RE: **SF-18-016 Kum & Go Final Plat Review 1**

Thank you for your review and comments regarding our Final Plat for Space Village Filing No. 3. Attached is the 2nd submittal for your review/approval.

The following are the County's comments dated June 15, 2018 along with Olsson's responses in red:

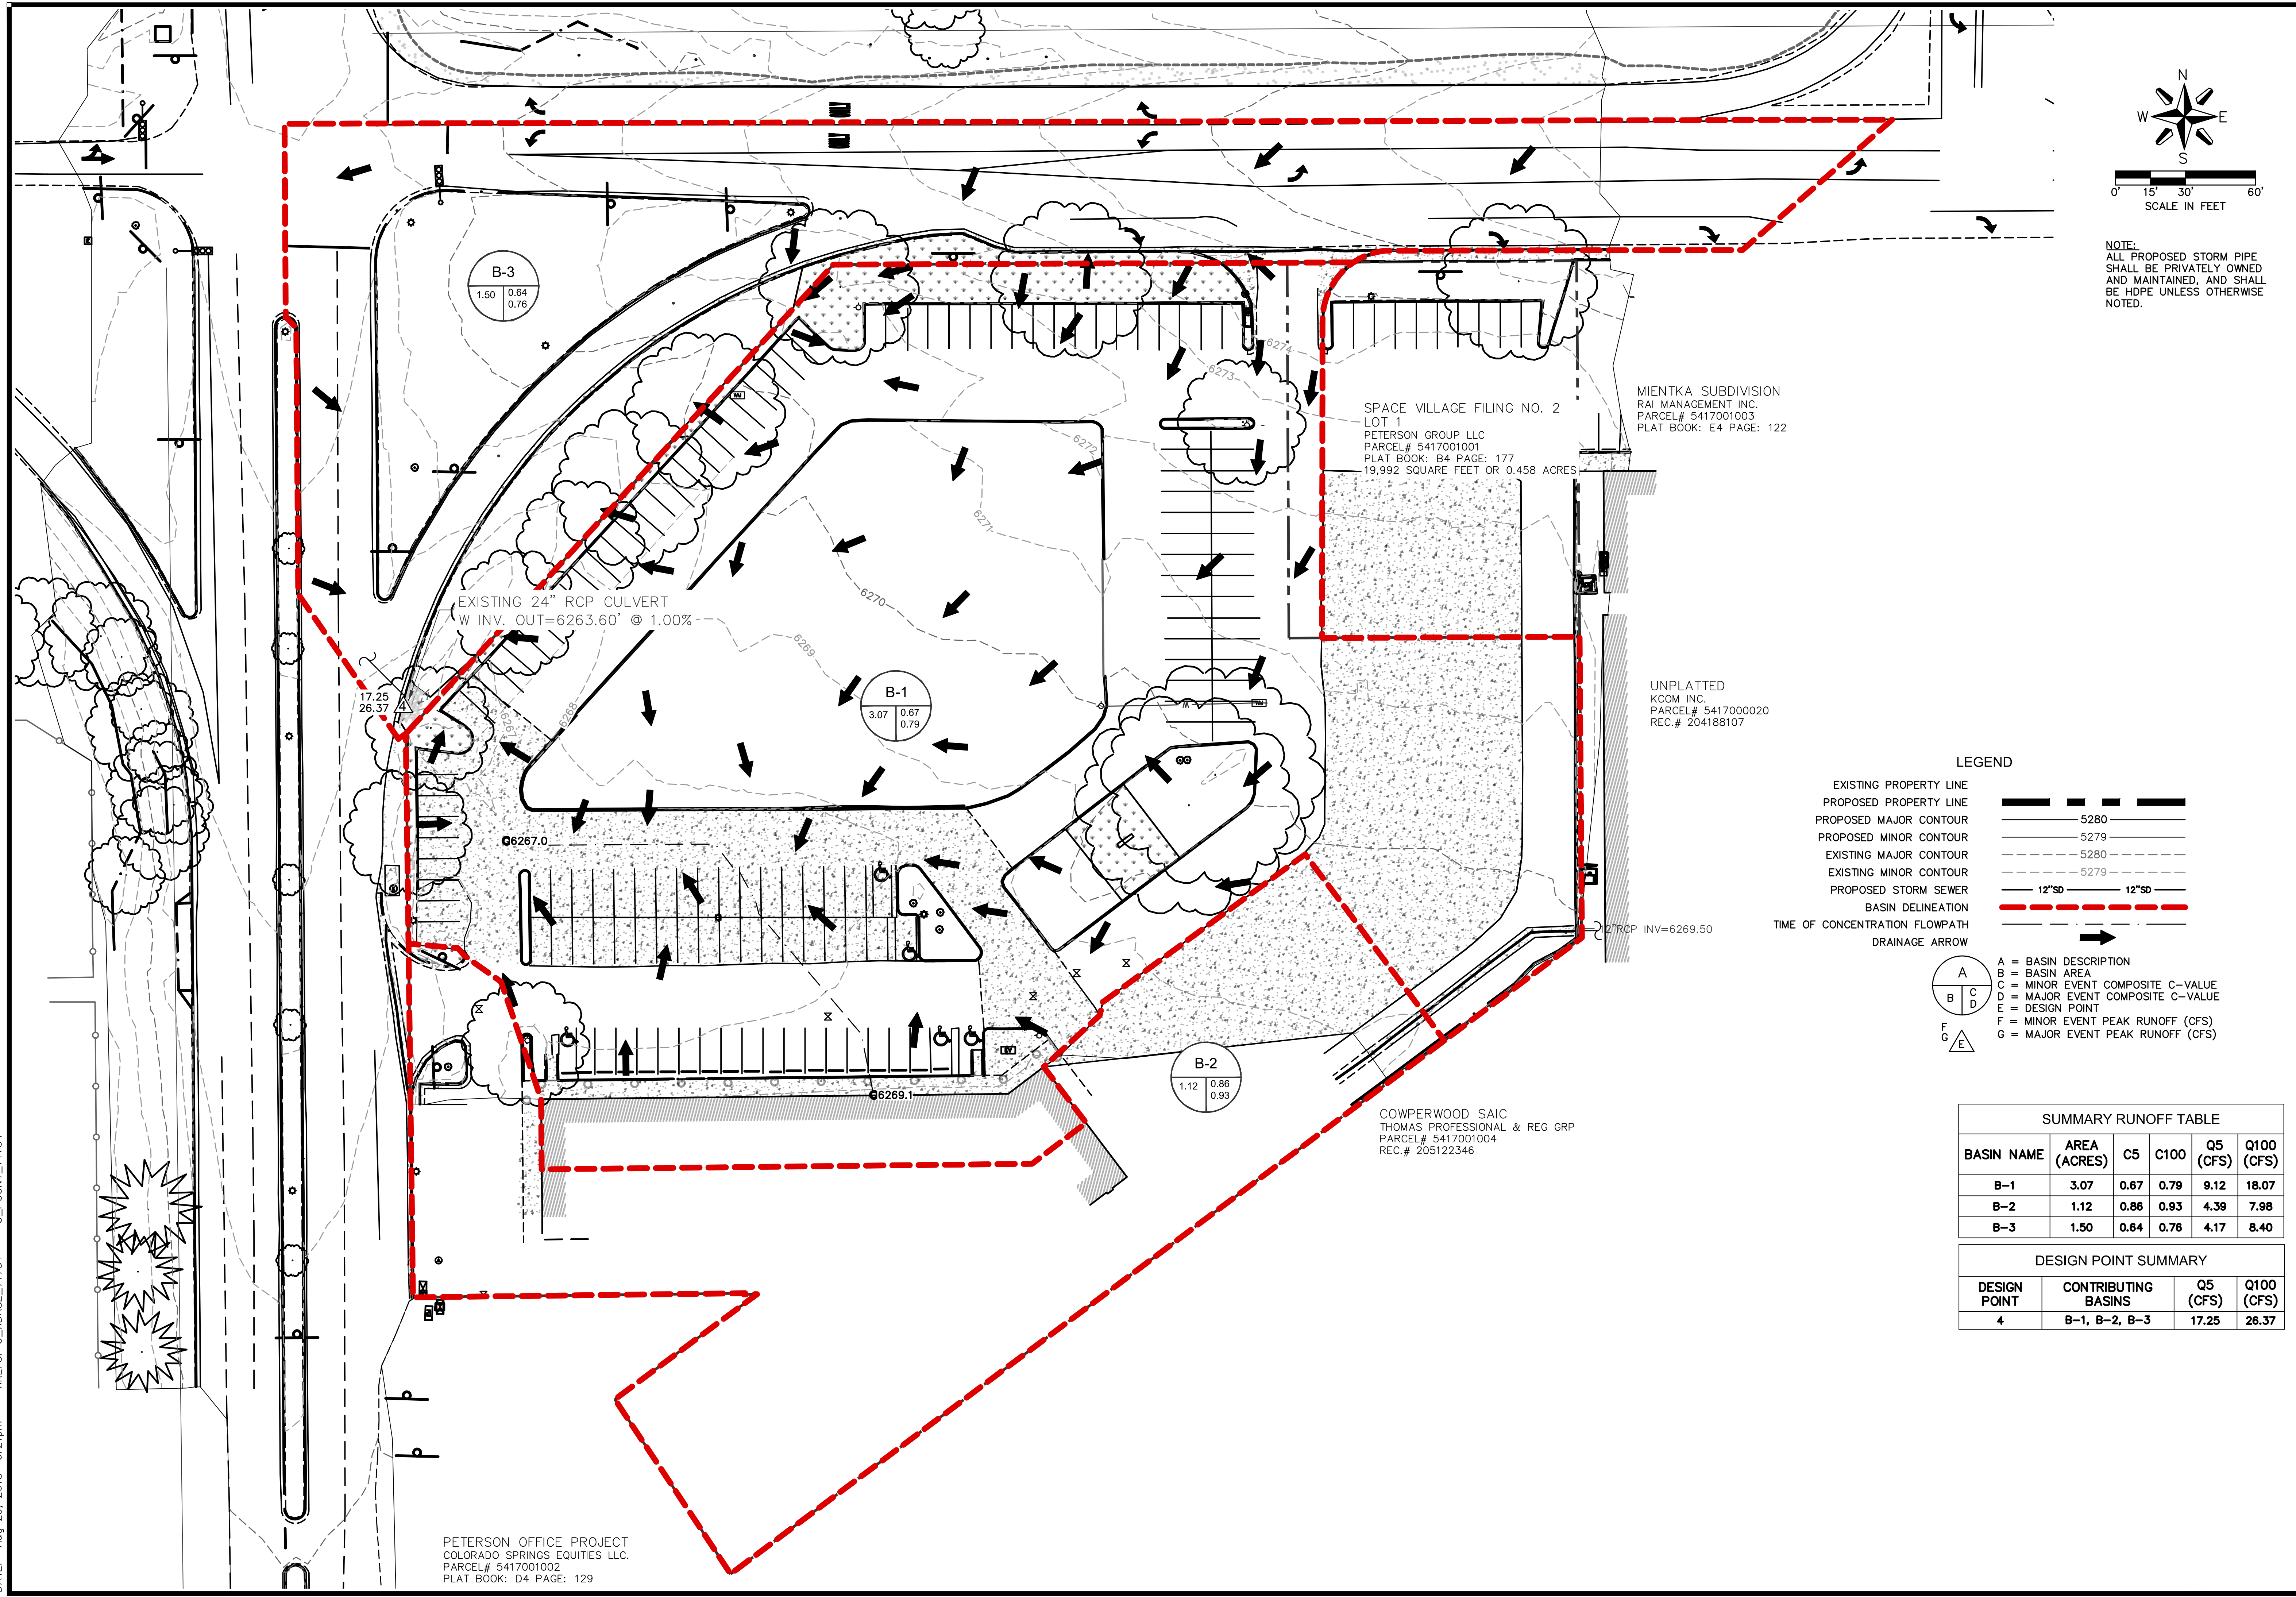
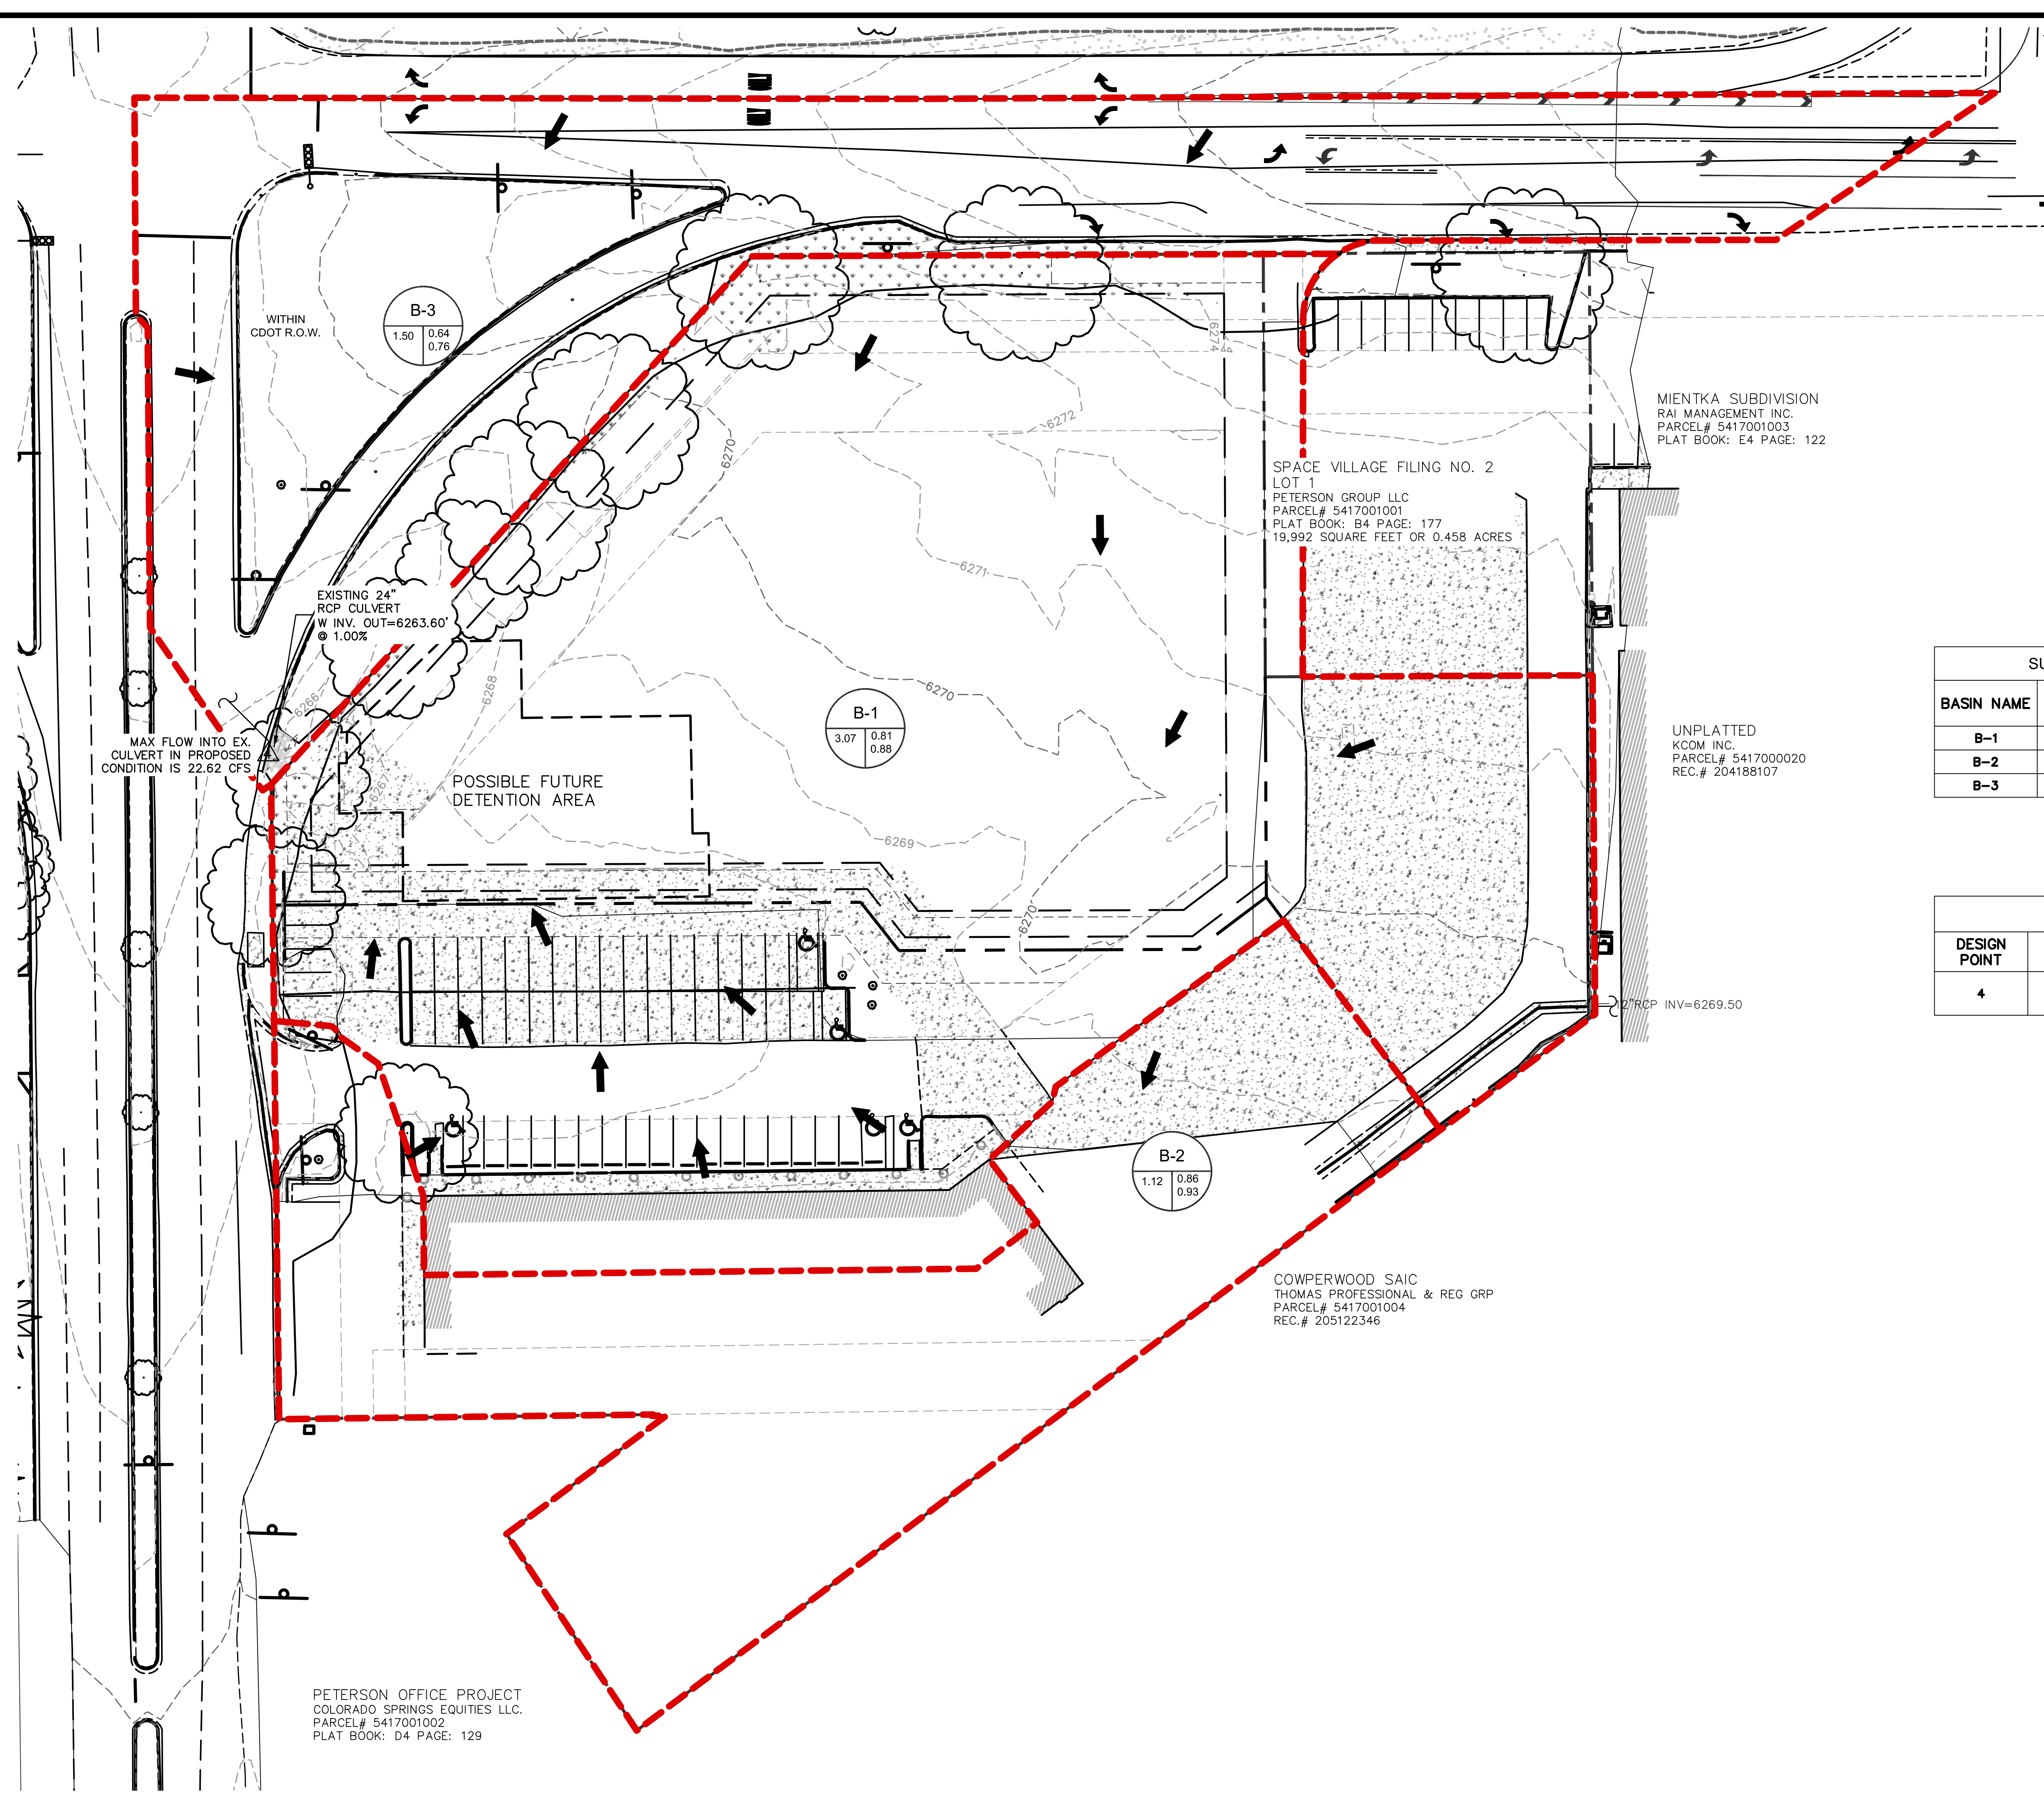
Peterson has discussed proposal with proponent and want to reiterate that all runoff and water is to be diverted away from Peterson AFB property near proposed development. Any drainage, outfall or system cannot discharge onto area west of Peterson Rd on installation property.

Per conversations with the AFB, the existing outfall (culvert under Peterson Blvd) will be utilized to convey runoff from Space Village Filing No. 3. This outfall pipe has historically been used to convey runoff from Space Village Filing No. 3. To mitigate downstream impacts, future development within Space Village Filing No. 3 (including the existing improvements on Lot 2) will be required to convey runoff to an onsite detention pond prior to releasing stormwater through the existing culvert. The onsite detention pond will be a full spectrum facility that will provide water quality and attenuation of the EURV and 100 YR release rates. The detention pond will ensure that future development within Space Village Filing No. 3 will release stormwater into the existing culvert at the same (or less) rate as in the current condition.
